Application for a non-material amendment following a grant of planning permission.

Number	
Suffix	
Property name	43-45
Address line 1	Reservoir Road
Address line 2	Surfleet
Address line 3	
Town/city	Spalding
Postcode	PE11 4DH
Description of site location must be completed if postcode is not known:	
Easting (x)	527840
Northing (y)	329263
Description

Residential development - three dwellings with associated parking and amenity space - outline approval H17-1149-18	
Reference number:	H17-0423-19
Date of decision	10/06/2019

Drawing No:EBD-004 43 Reservoir Road Surfleet Second NMA Drawings Rev C

Proposed Front Elevation
Scale 1:100 @ A1

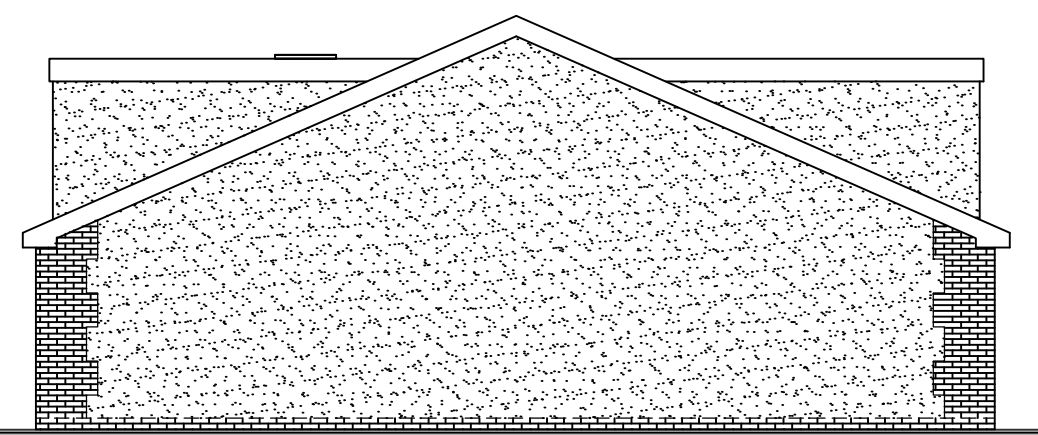
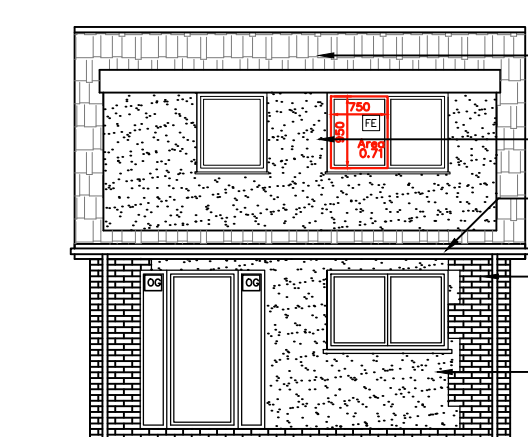
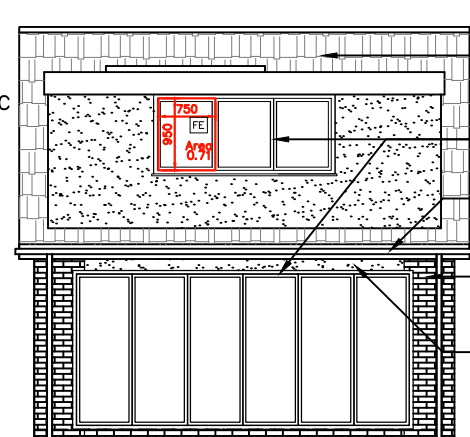
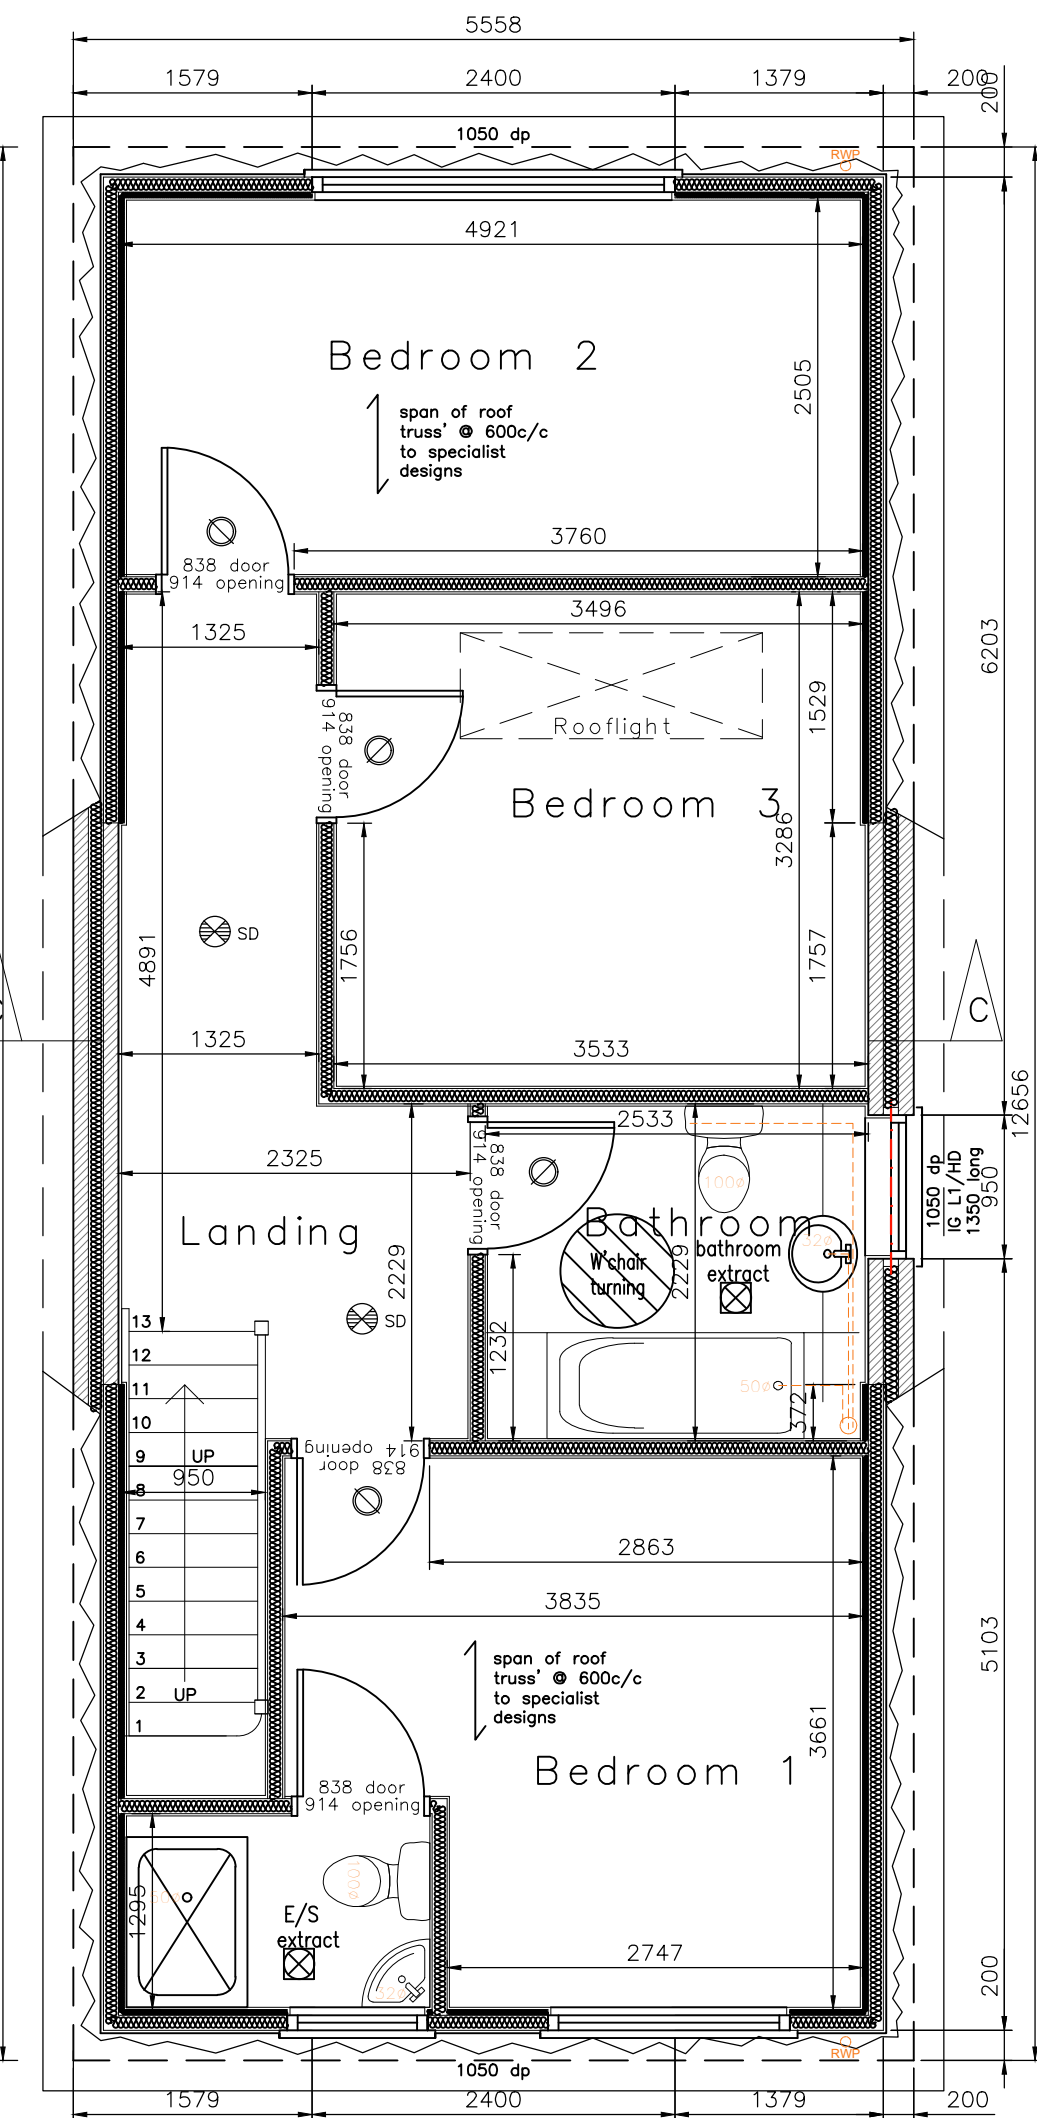
Internal amendments to layout of ground and first floor, front entrance door to change from a double door to a single door with side windows. Window and door finished changed from white uPVC to black uPVC. PVC u beading render. Position of air source heat pump indicated and roof light to flat roof dormer changed to a flat velux type from dome shaped.
